Subject: RE: Crawshaw Farm 3/2012/0060

Reducing the proposed wind turbine's blade tip height to 22.5m ('micro scale', ref. *Forest of Bowland AONB Renewable Energy Position Statement*) would have a beneficial effect on the significance of likely landscape and visual impacts. In comparison with the initial proposal for a 29.2m blade tip height wind turbine, the smaller turbine would be visible over a noticeably smaller area. In particular, a long section of Back Lane would lose visibility of the turbine and areas around Tenter Hill, Gaughey Hill, Wood House Lane, Townfield Plantation and Pain Hill Moor would also lose visibility. Where the turbine would be visible it would appear as a less dominant and notable feature in the landscape (e.g. photomontage 1). In addition, the micro scale of the turbine would be more appropriate for the medium scale of the landscape. Locating the turbine to within less than 100m of the nearest farm building as is now proposed would also establish a much stronger visual relationship with the property that it provides power to (e.g. photomontage 3).

XZERES 442SR WIND TURBINE

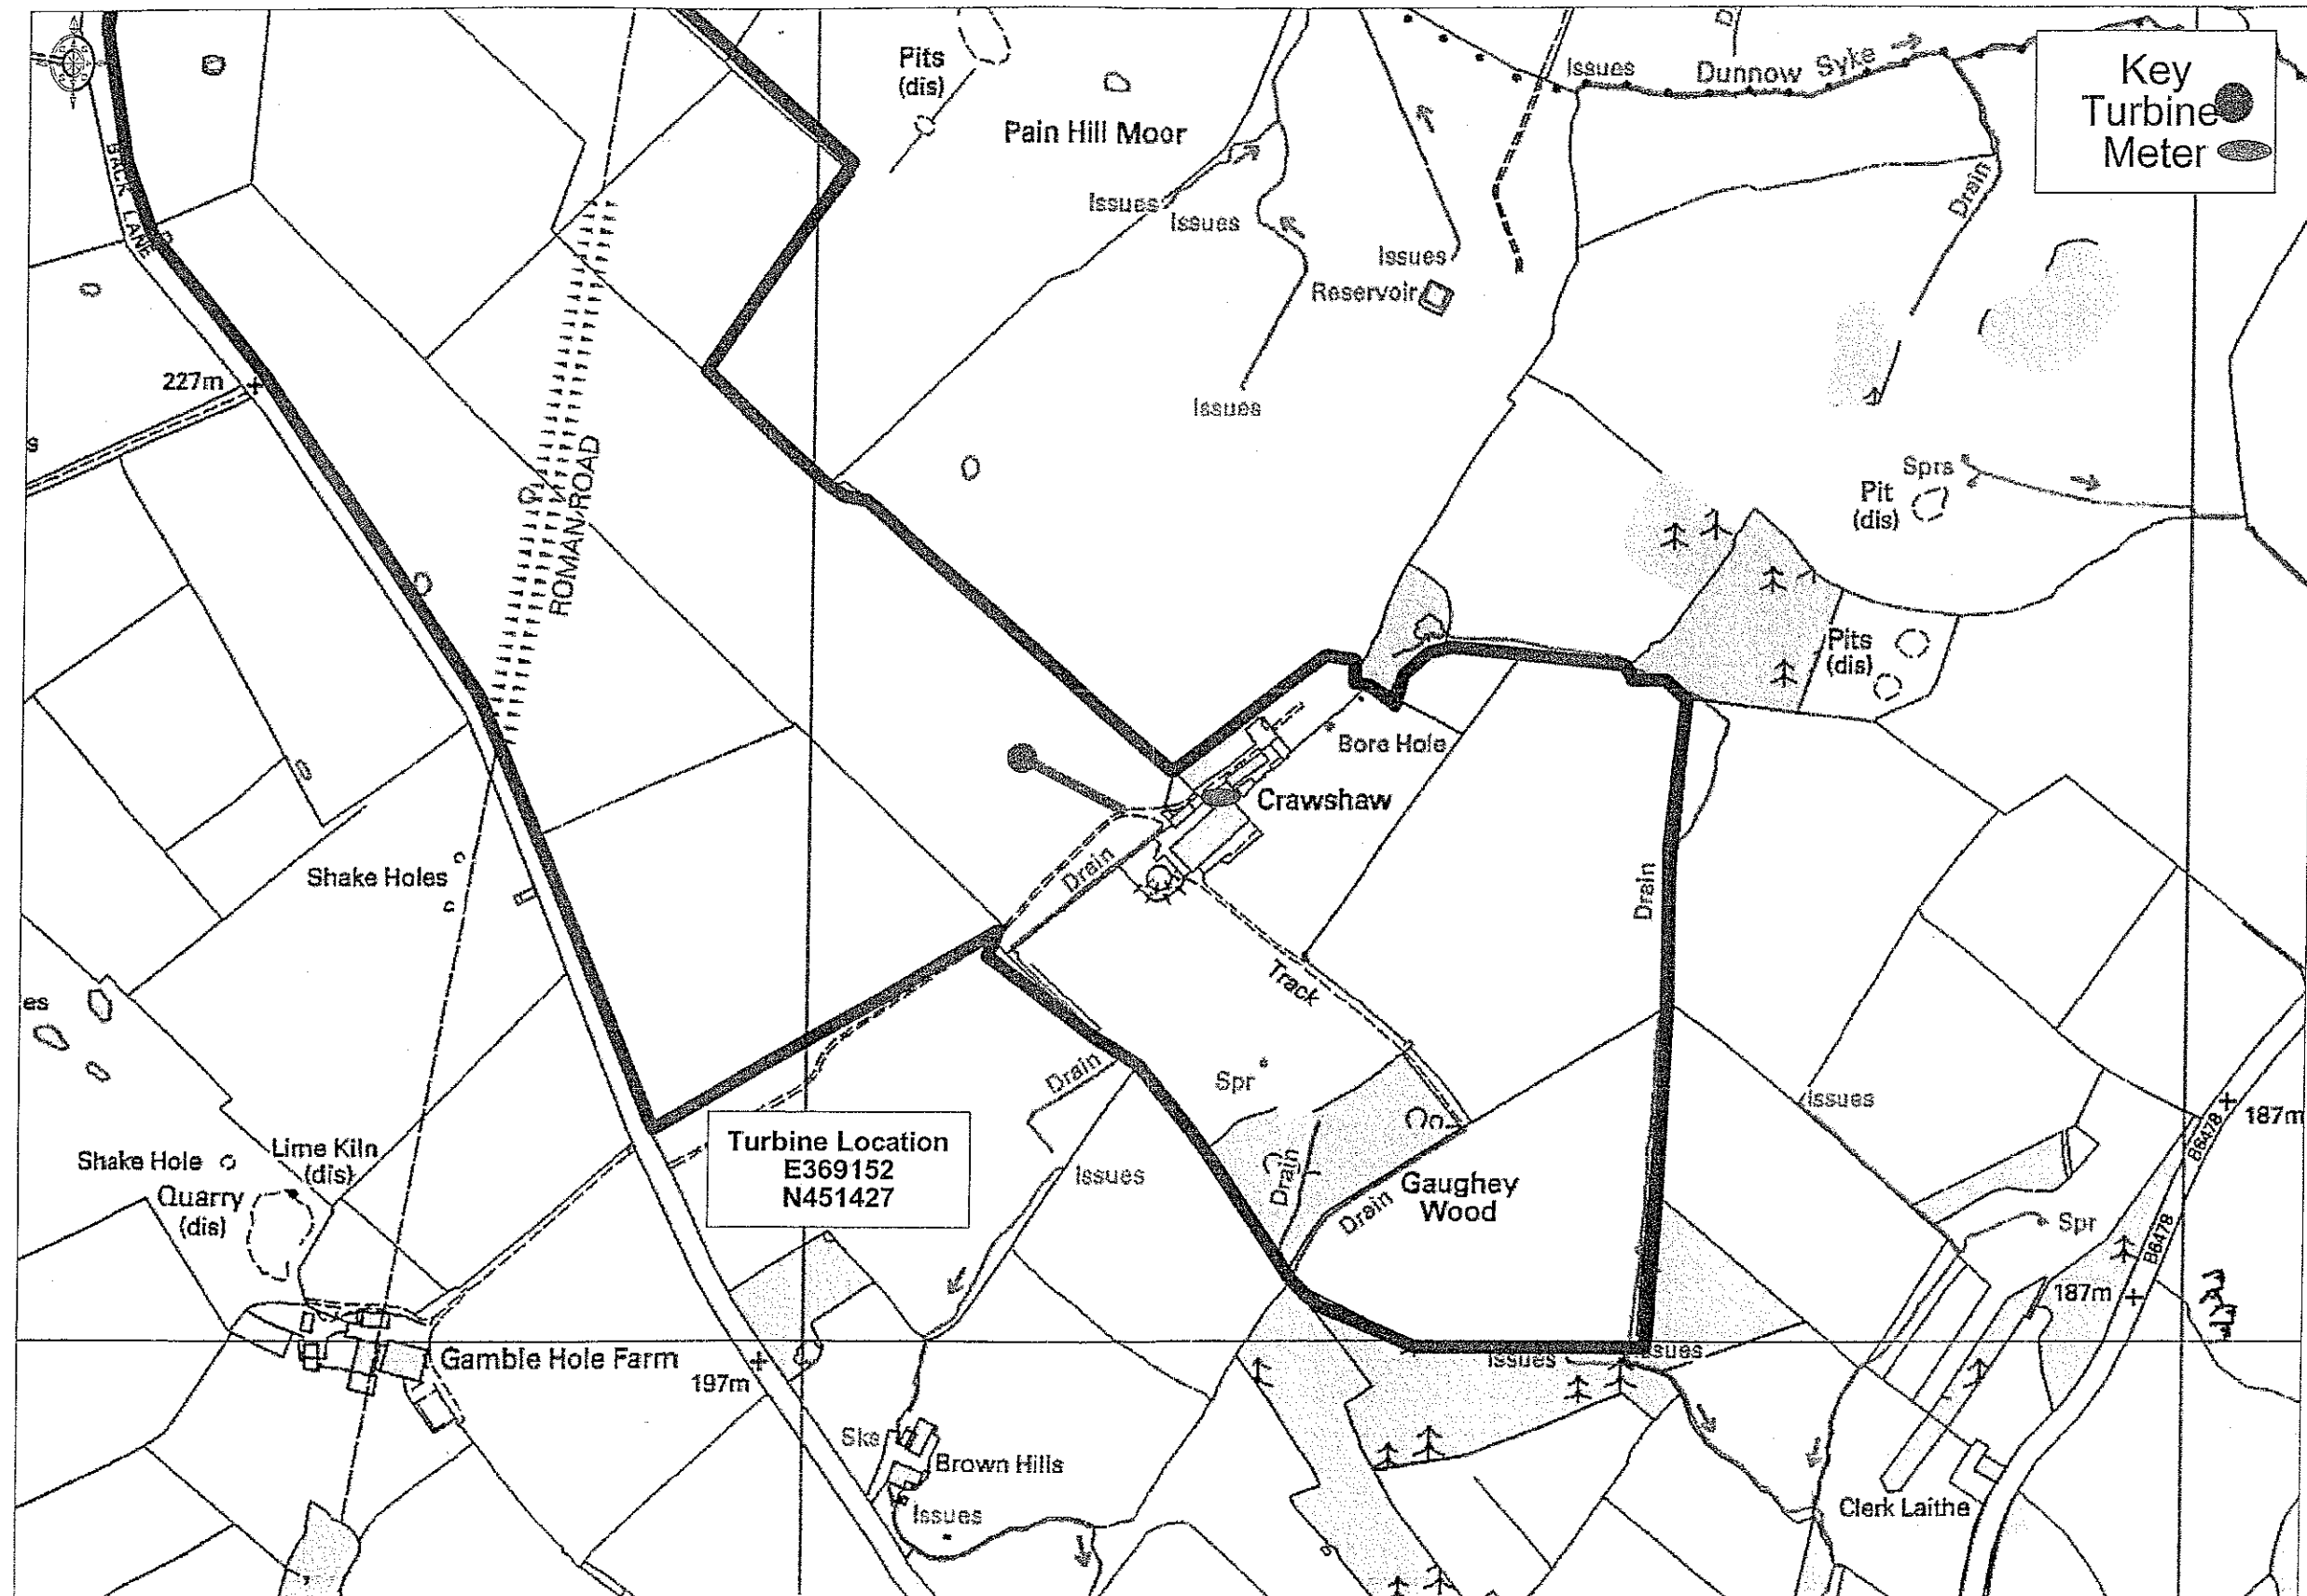
Should the authority be minded to approve the application, I recommend that consideration be given to having a slightly darker grey surface finish than usual as the wind turbine would be seen in many views against Beatrix Fell, Dunsop Fell and Low Fell rather than the skyline. A slightly darker colour should aid the wind turbine's assimilation into the landscape.
